# CITY OF PORTLAND

Job ID: 2011-04-736-ALTCOMM

has permission to Construct a 12 'x 16' equipment shelter, add appurtenances to existing communication tower & generator provided that the person or persons, firm or corporation accepting this permit shall comply with all of the provisions of the Statues of Maine and of the Ordinances of the City of Portland regulating the construction, maintenance and use of the buildings and structures, and of the application on file in the department.

**Jeanie Bourke - RE: FW: US Customs & Border Protection tower site building permit - 225 Riverside Industrial Parkway**

1
C3 TOWER ELEVATION
SCALE: N.T.S.

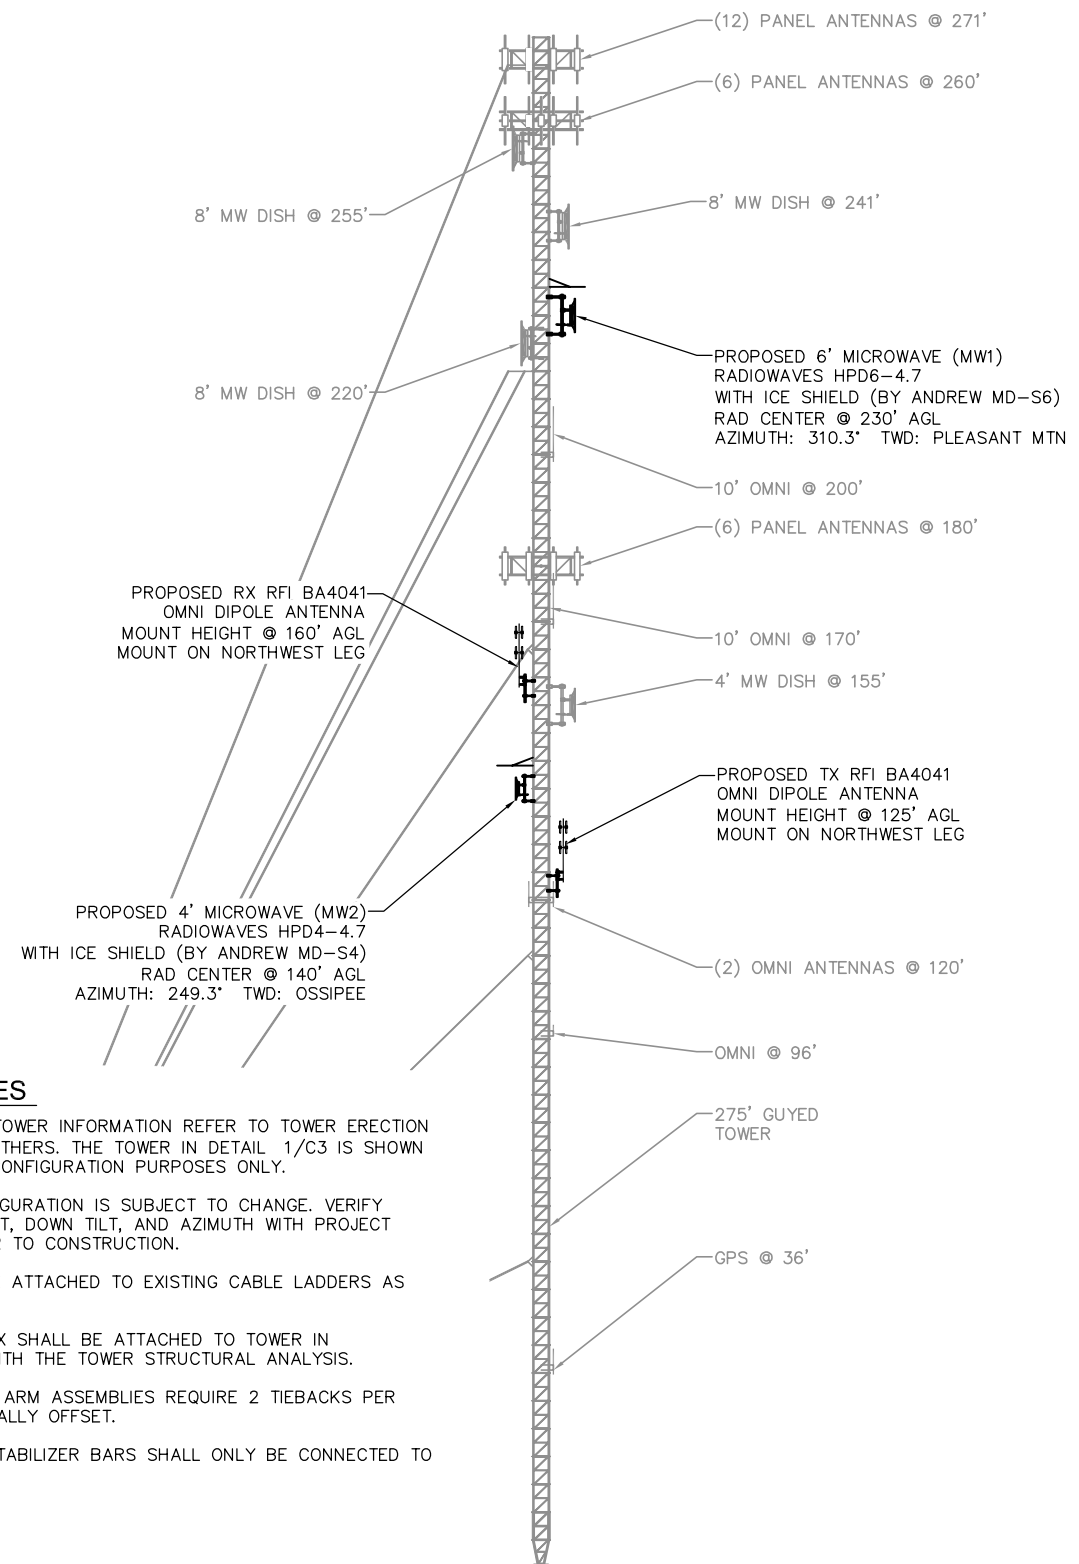
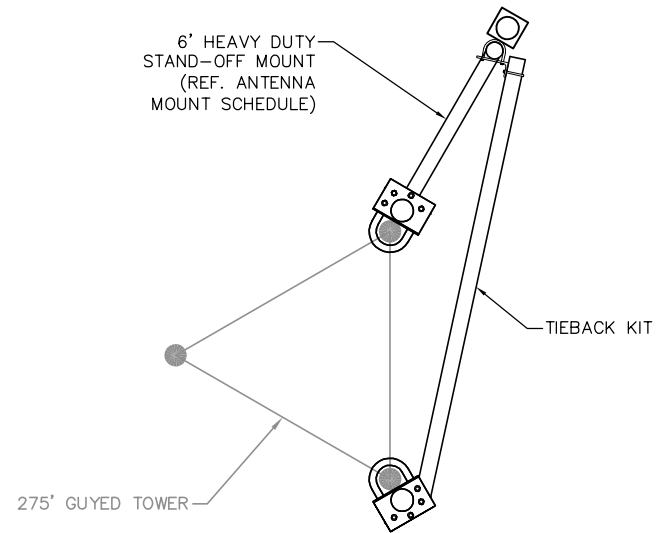
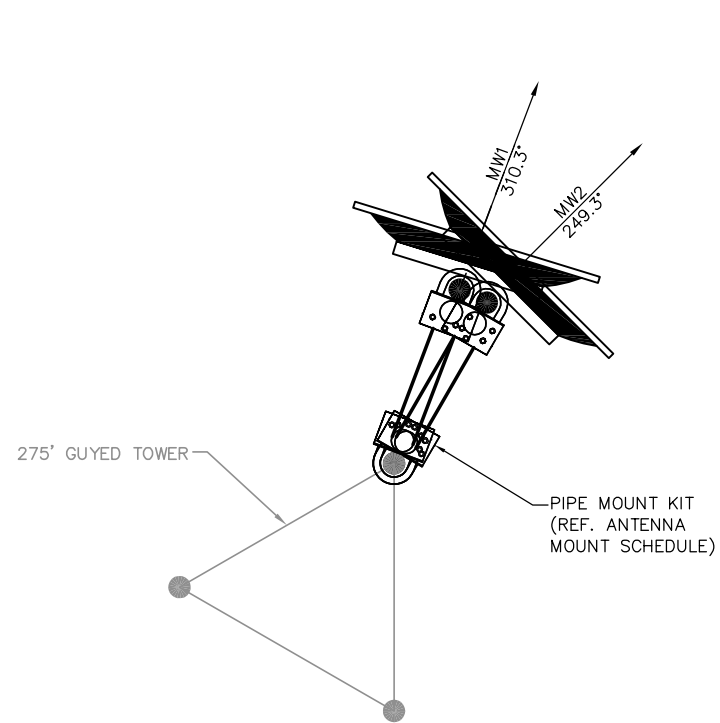
1. Please provide stamped construction drawings, details of the building construction (it appears only the foundation is supplied),
2. Tower mounting kit specs and details,
3. Engineers assessment that the tower is structurally designed to accept the loads of the proposed additional equipment,
4. A condition of the permit will require confirmation by a licensed professional that the installation of the equipment is in compliance with the design standards.

I have also attached a copy of the PE sealed tower structural analysis that shows the tower passes with the proposed additional loading as well as the mounting kit details you requested.
